Reference No:	2024/62/90552/E
Site Address:	73, Park View, Park Side, Flockton, Wakefield, WF4 4AF
Description:	Demolition of existing outbuilding and erection of single storey side extension with rear decking and external alterations
Recommending Officer:	Nicole Helliwell

Officer Report

Reference No. 2024/62/90552/E

Proposal: Demolition of existing outbuilding and erection of single storey side extension with rear decking and external alterations

Project
**73, Park View, Flockton,
Wakefield, WF4 4AF**
Drawing title
Proposed Elevations

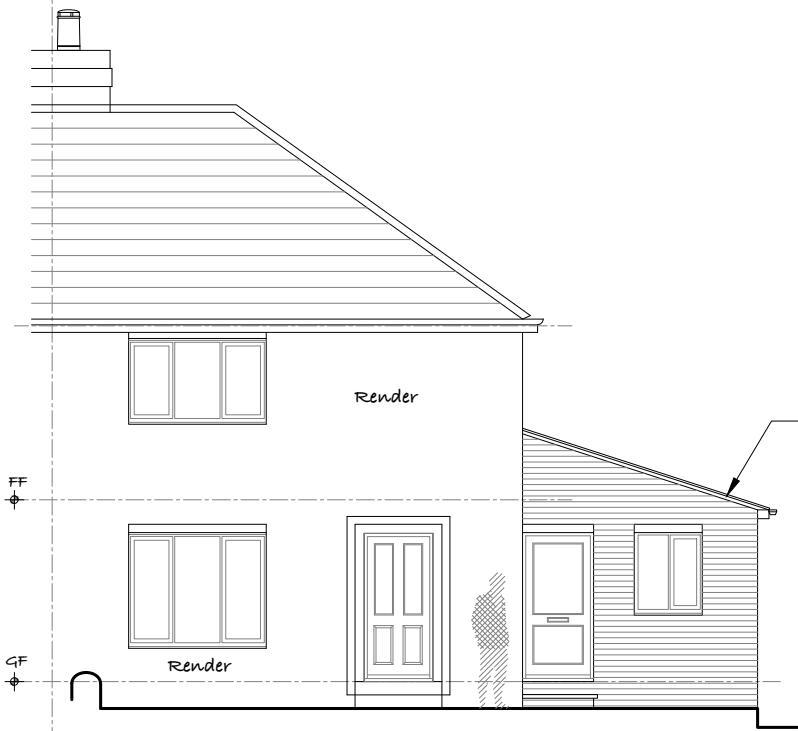
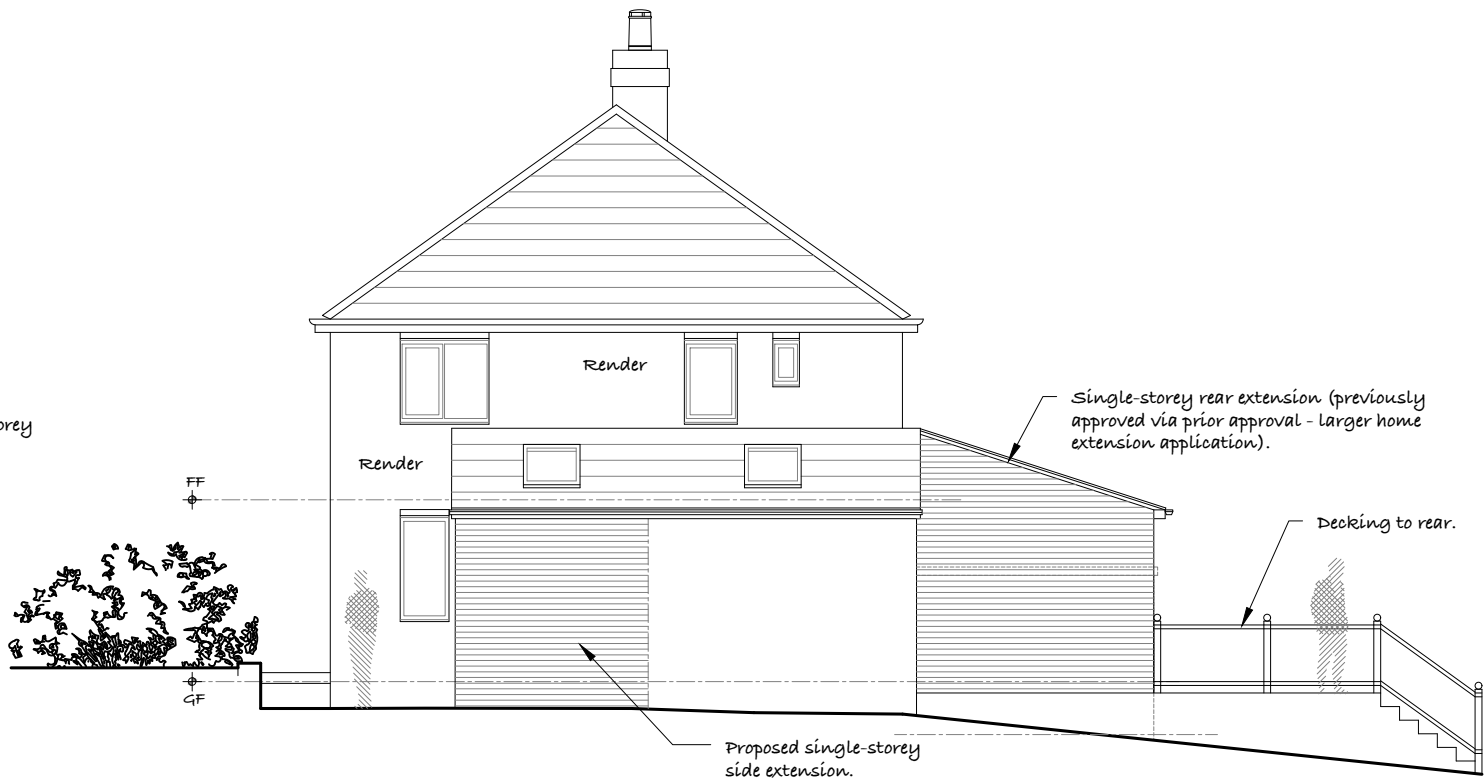
The proposal seeks to apply render to the front, rear and side elevations of the dwelling. Although the use of render would alter the appearance of the host property, it is noted that render is prevalent within the immediate street scene. Whilst there is no planning history for the application of render at no.83 and no.89, render now forms a characteristic of the street scene. Therefore, in this specific context, it is considered that the proposal would not have any significant visual impact on the character and appearance of the host property and wider street scene.

The raised decking with a timber balustrade and steps would be located to the rear of the dwellinghouse. The decked area would project approximately 2m from the rear elevation of the property and would have a height ranging from 0.6m to 0.9m due to changes in topography. However, due to its siting, the proposed development would have limited visibility from public vantage points and is not considered to have a significant visual impact on the character and appearance of the host property and surrounding area.

3. Notwithstanding the submitted plans and information, the external walls of the original dwellinghouse shall be faced in white render and retained thereafter.

Drawing title
Proposed Block Plan, Floor/Roof Plan

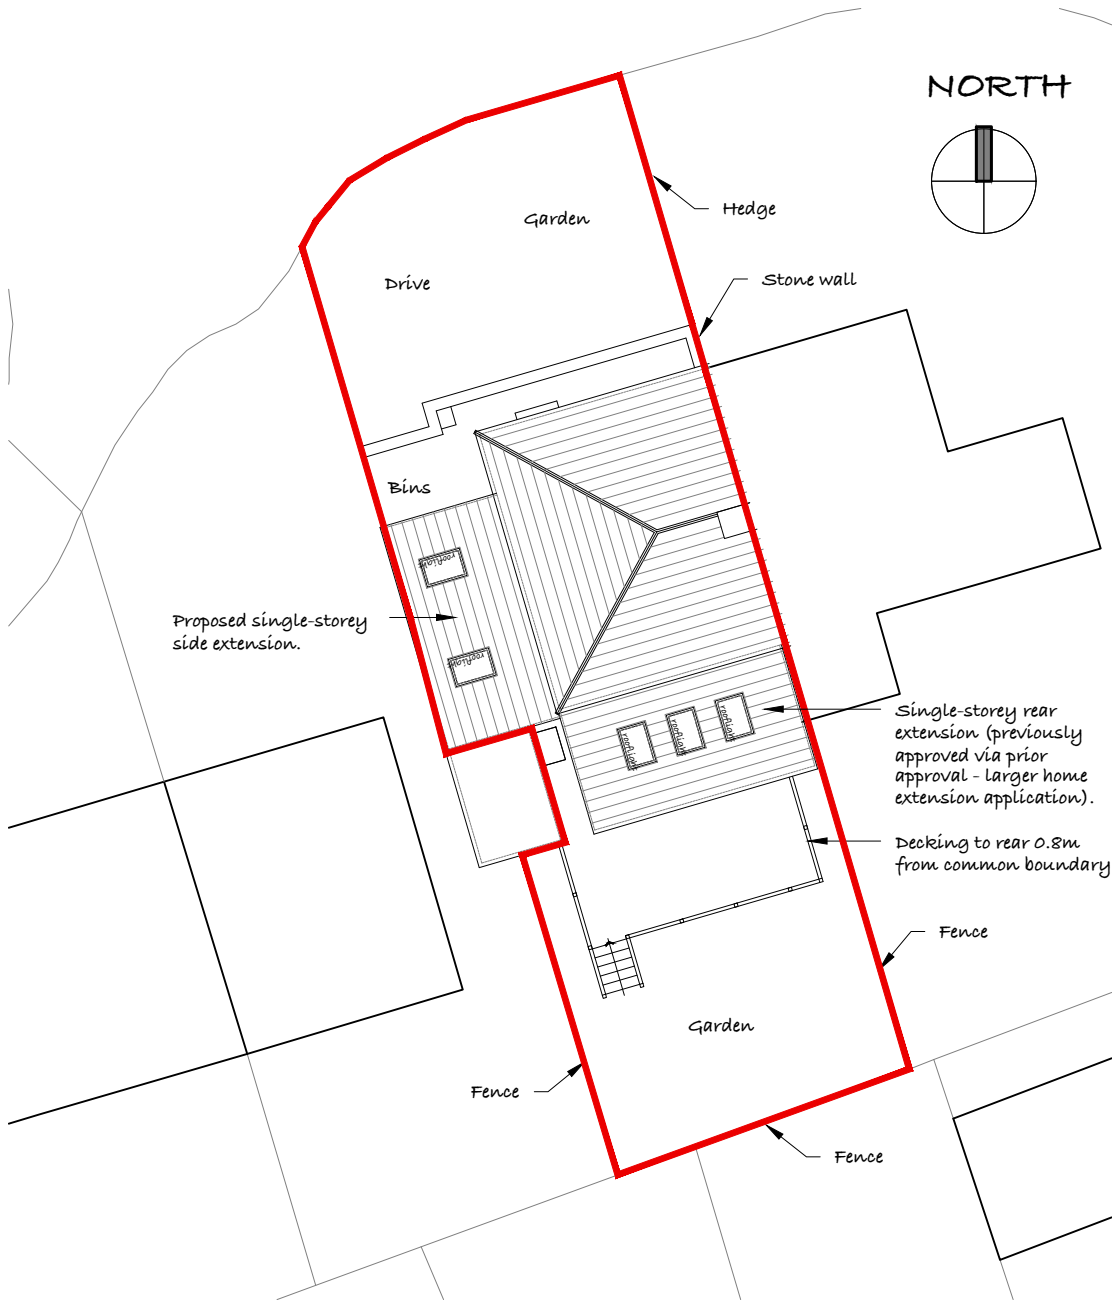
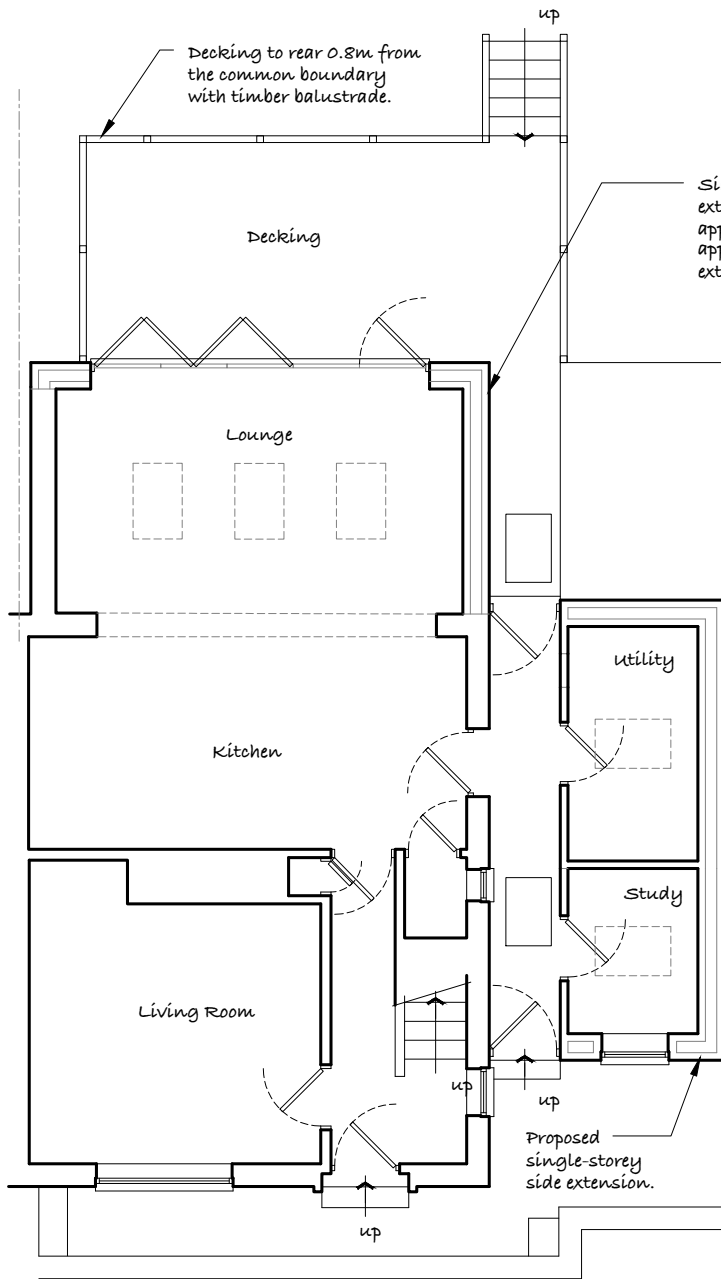
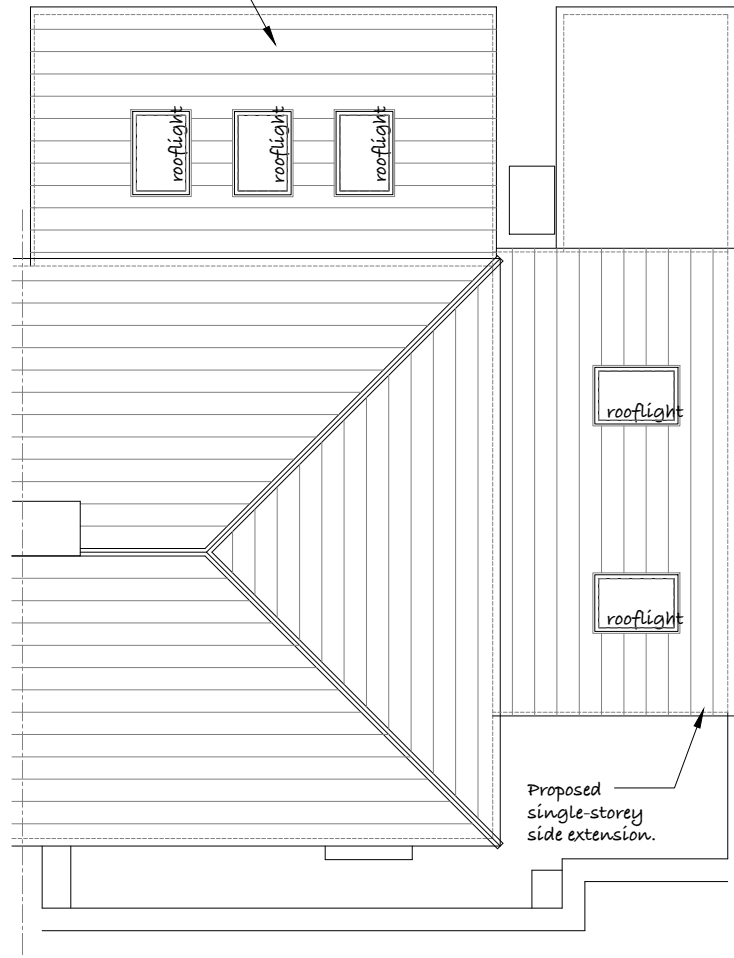
71 Park View is the adjoining property to the east of the application site. The proposed single storey side extension would not surpass the neighbour's front and rear elevations and would be acceptable in this regard. Furthermore, it is noted that the raised decking would be positioned approx. 0.8m from the boundary line. Due to its elevated position, the landing may create some additional overlooking. Therefore, to alleviate any undue harm, a condition has been added requiring a 1.8m high obscure glazed screen to be installed to the eastern side of the raised decking and retained thereafter.

Amendments were sought during the course of the application. A request was made to set the raised decking to the rear of the property approx. 0.8m from the common boundary shared with 71 Park View to prevent a harmful overlooking relationship. Revised drawings were received which were considered acceptable with regard to residential amenity.

5. Upon first construction, a 1.8m high privacy screen shall be installed to the eastern side of the raised decking and retained thereafter in perpetuity.

Project
**73, Park View, Flockton,
Wakefield, WF4 4AF**
Drawing title
Proposed Elevations

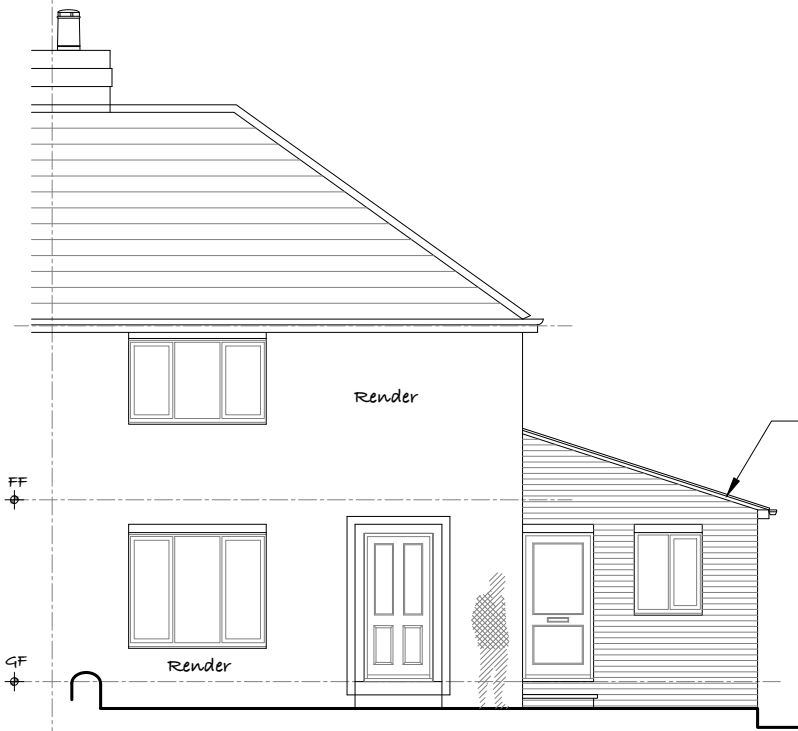
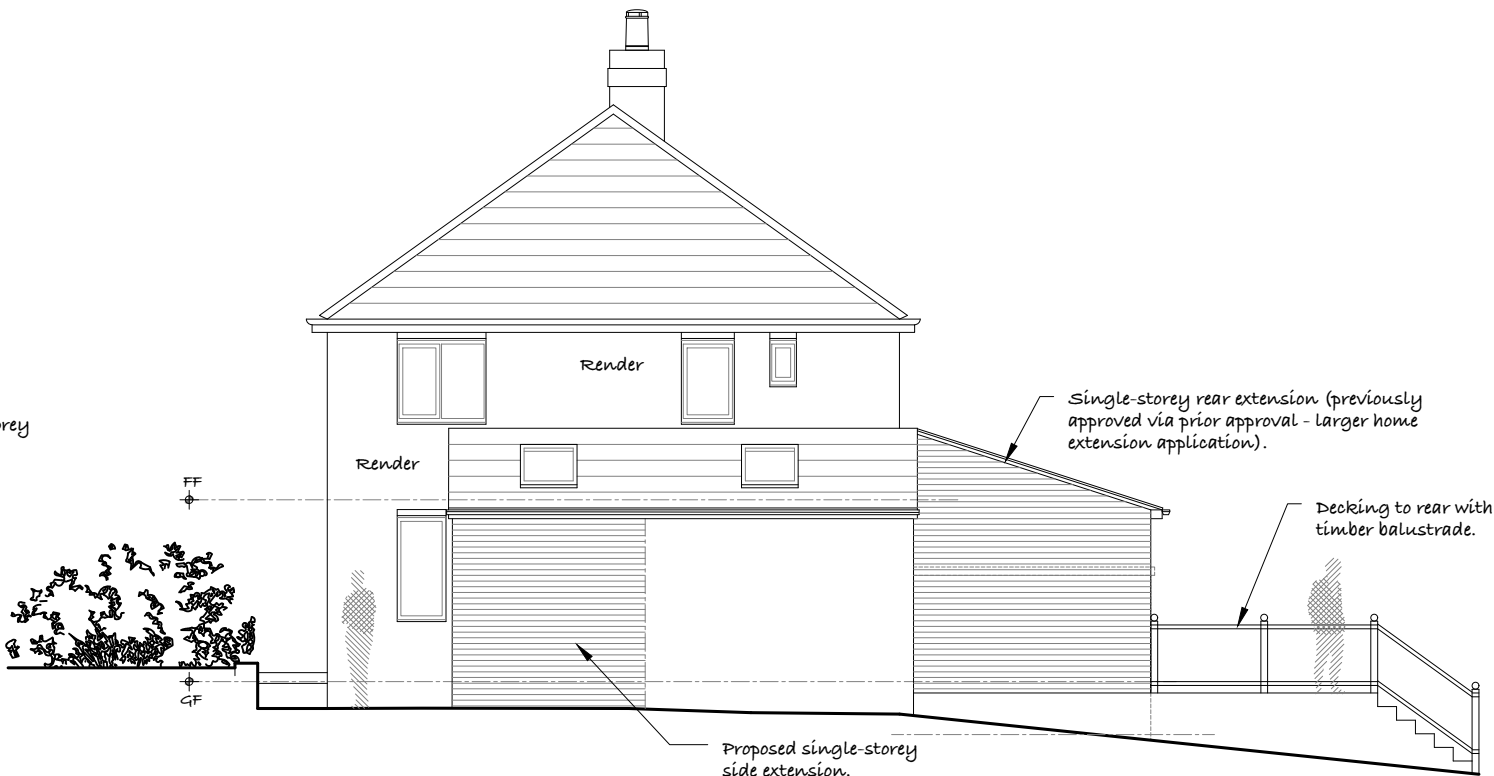
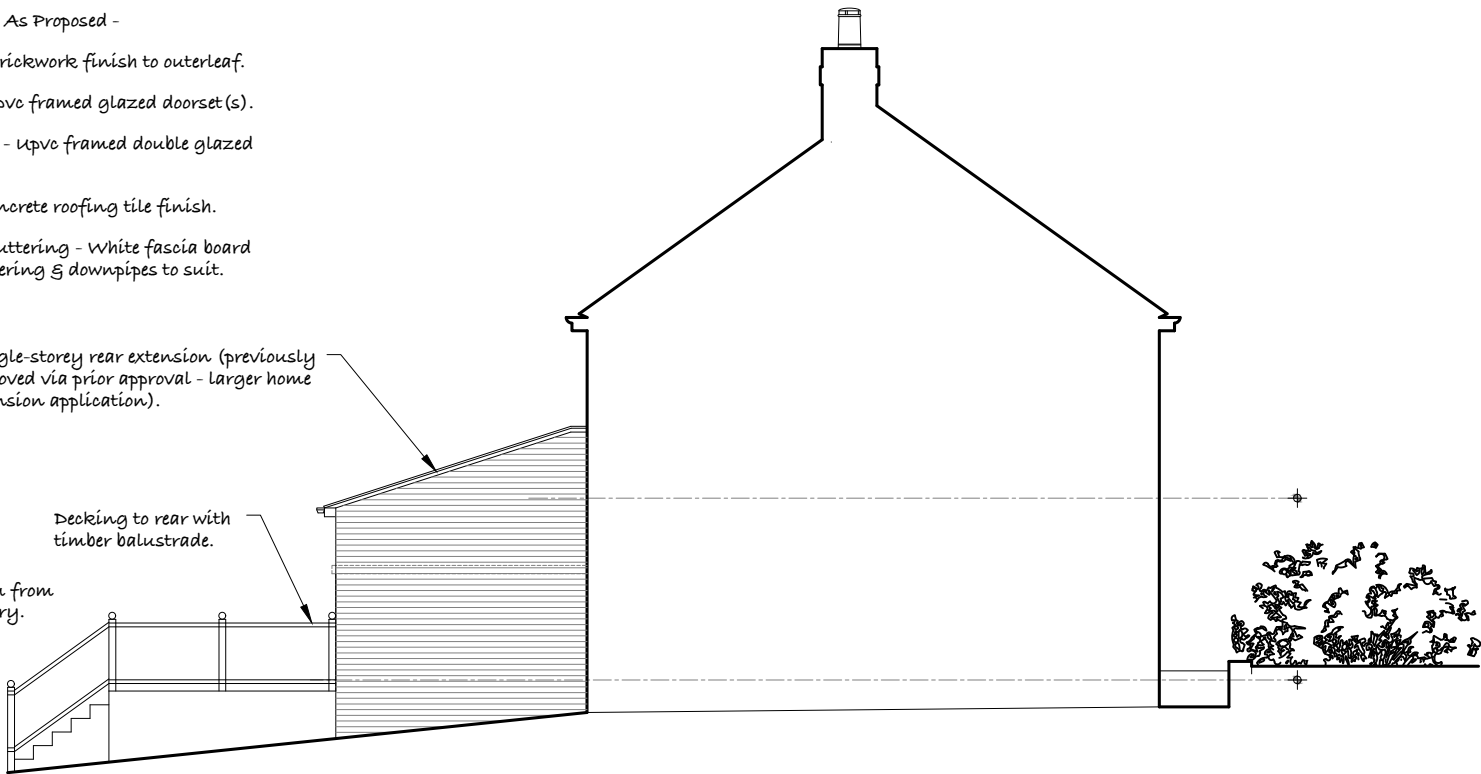
The proposed single storey extension would project approximately 3.12m from the side elevation of the original dwellinghouse. The enlargement would be faced in red brick and would incorporate a mono-pitched roof finished in concrete tiles to match the appearance of the original build. The extension would be modestly proportioned and would have an acceptable scale relative to the host property. Furthermore, the enlargement would be set back approx. 1.7m from the principal elevation and approx. 7.7m from the public pavement, which would reduce its prominence from public vantage points. For these reasons, it is considered that the proposal would not have any significant visual impact on the character and appearance of the host property and wider street scene.

4. The external walls of the single storey extension hereby approved shall be faced in red brick for the external walls and concrete tiles for the roof. The materials of construction shall thereafter be retained for the lifetime of the development.
